City of Portland, Maine - Building or Use Permit Application

Location of Construction: 21 Kingsmark Ln		Owner Name: Peverada Judith A &		Owner Address: 21 Kingsmark Ln		CBL: 227 E020001	
Business Name:		Contractor Name: no contractor / self		Contractor Address: Portland		Phone: 207-874-8444	
Lessee/Buyer's Name		Phone:		Permit Type: Alterations - Dwellings			Zone:
Past Use: single family		Proposed Use: finish 16' x 28' room over garage		Permit Fee: \$44.00		Cost of Work: \$3,000.00	CEO District: 3
Proposed Project Description: finish 16- x 28' room over garage		FIRE DEPT: <input type="checkbox"/> Approved <input type="checkbox"/> Denied		INSPECTION: Use Group: R-3 Type: 5B			
				Signature: [Signature] Date: 4/30/02			
				PEDESTRIAN ACTIVITIES DISTRICT (P.A.D.) Action: <input type="checkbox"/> Approved <input type="checkbox"/> Approved w/Conditions <input type="checkbox"/> Denied Signature: _____ Date: _____			
Permit Taken By: Jodinea		Date Applied For: 04/25/2002		Zoning Approval

Status: Approved with Conditions

PEVEADA ATT. + FLOOR PLAN

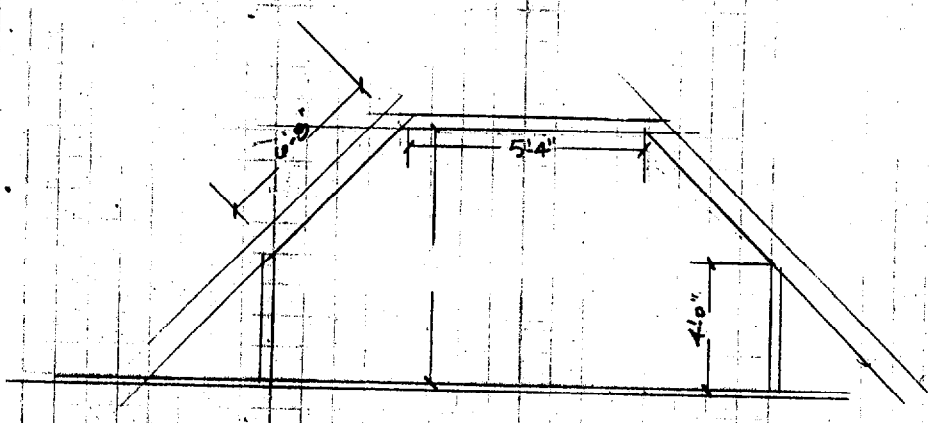
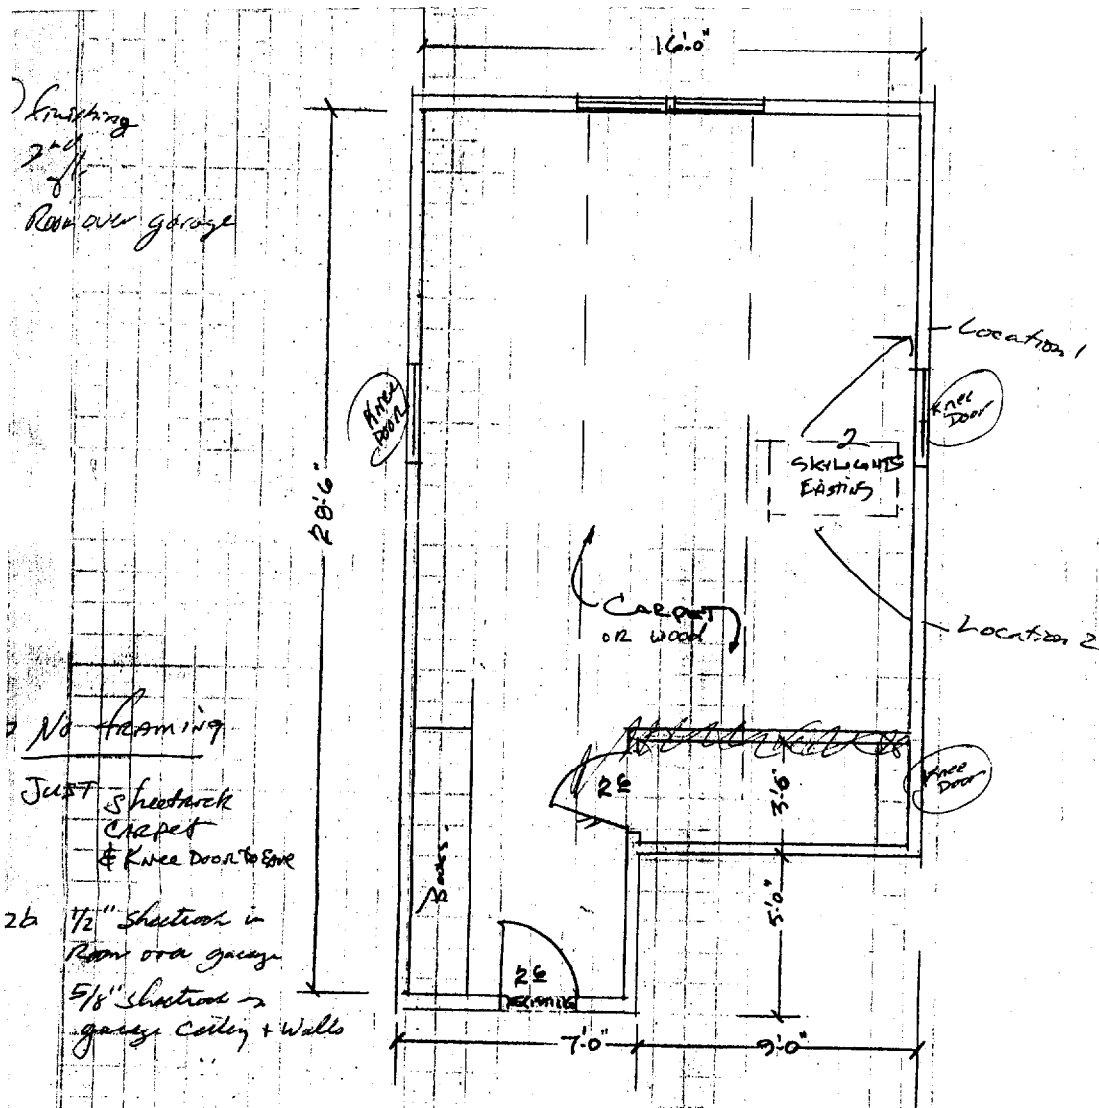
CANNOT BE USED AS A SLEEPING ROOM unless a code compliant egress (5.7 sq.ft.) window is present meeting all egress window requirements and an AC/DC Smoke detector is interconnected to the existing smokes in the house.

Garage area must be completely fire rated (1HR) including interior door, walls ceiling and existing beam.
